Our ref: AN/2024/135560/03-L01
Your ref: EN010130
Date: 24 October 2024

Application by GT R4 Limited (trading as Outer Dowsing Offshore Wind) for an order granting development consent for the Outer Dowsing Offshore Wind Project (Generating station and transmission infrastructure)

SLR Project Number: 410.V05356.00013

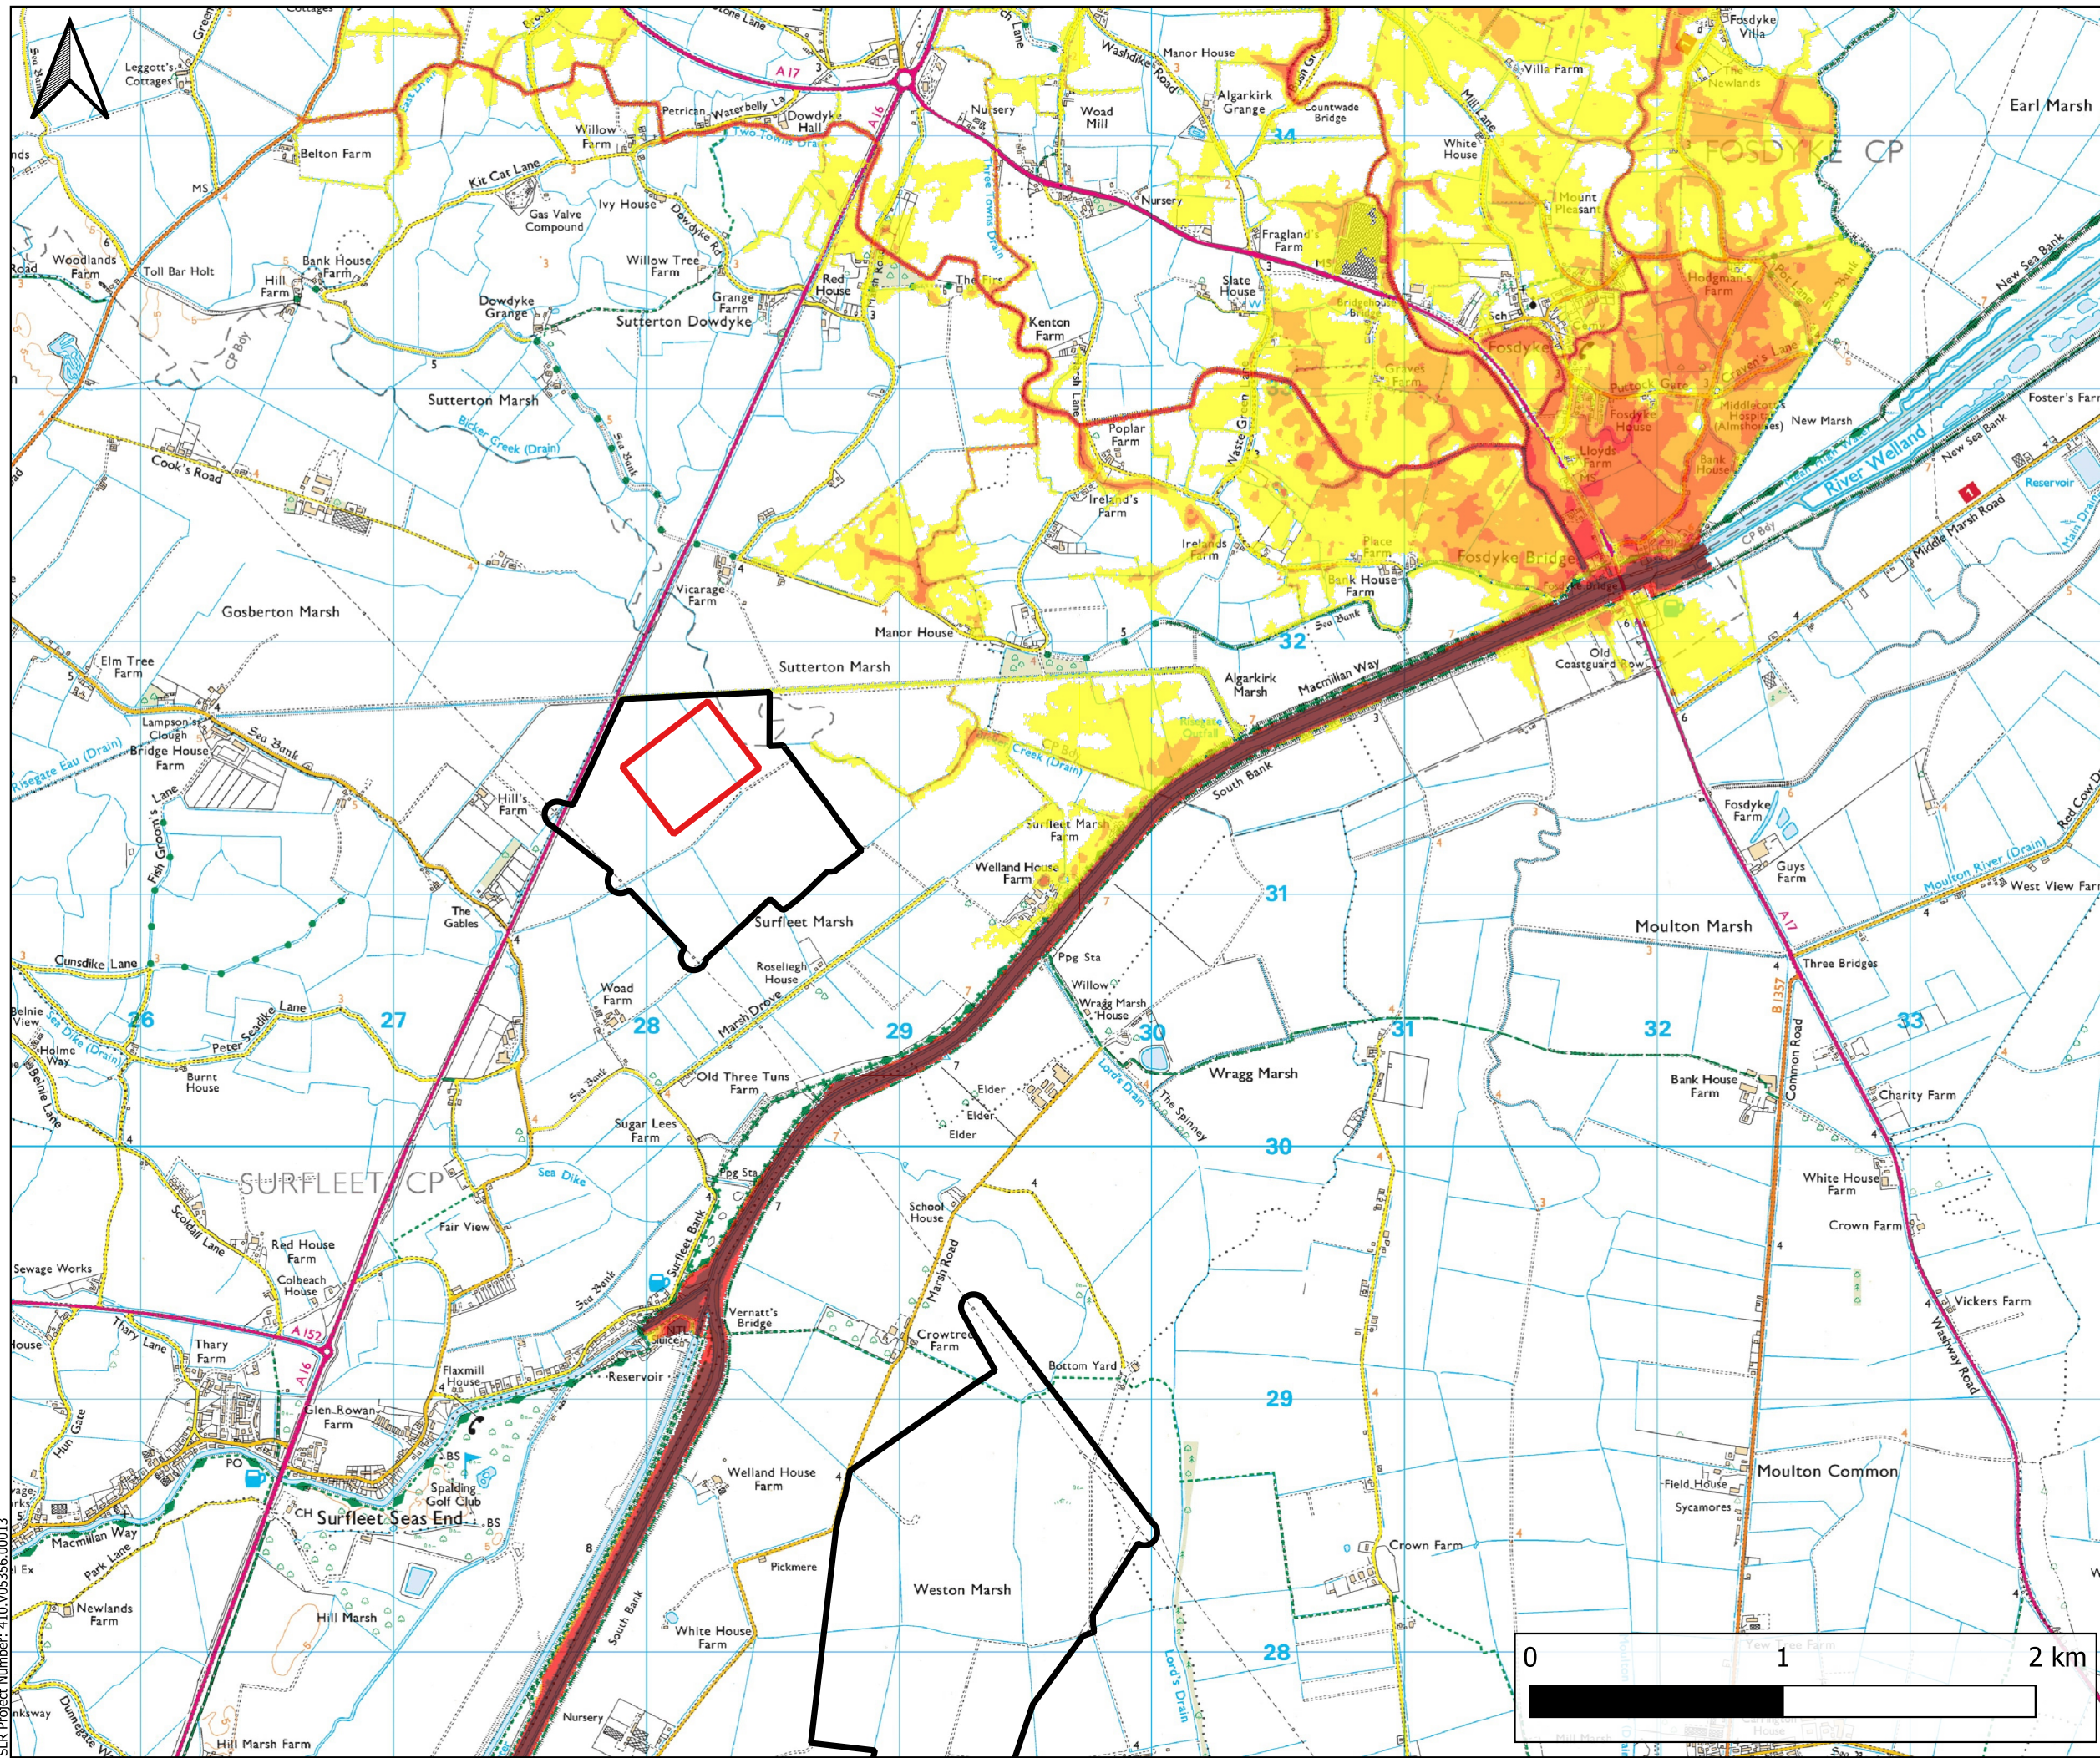
- 8.0 **Chapter 24 Flood Risk; Chapter 24 Appendix 3 Flood Risk Assessment Onshore Substation (OnSS)**
- 8.1 **Hydraulic modelling of the OnSS** – The Applicant provided an updated version of the River Welland Breach Modelling (Version 3) to the Environment Agency on

25 July 2024. We undertook a review of this, but there are queries that still need to be addressed – these were communicated to the Applicant on 10 September 2024, and we are currently awaiting a response to these. Therefore, we are not yet able to provide any further advice on this matter.

- 8.4 The FRA has not considered (or assessed) the potential scenario that the OnSS may remain in place beyond the 35-year design life in relation to the impact on 3rd parties and climate change. As the OnSS is to be built on a raised platform the Applicant must assess whether this land raising will increase the risk of flooding elsewhere. The assessment can only be limited to the 35-year design life if it is accompanied by a Requirement that the OnSS is decommissioned in 2065, and the land returned to its original level – there is currently no requirement in the DCO to ensure this happens. Without such a decommissioning requirement there is a chance that the OnSS may remain operational beyond its 35-year design life (component parts may be renewed/replaced) and the impacts of this on 3rd parties have not been assessed.

- 8.7 In line with the above policy requirements, the Environment Agency requests that the Applicant either carries out an assessment of the raised platform and OnSS remaining in place beyond 2065 (using at least 75 years to form a starting point) and in particular the impact this will have on 3rd parties in relation to climate change. Alternatively, the DCO must include a requirement to ensure the OnSS is fully decommissioned in 2065 and the land restored to its original, pre-construction, level.
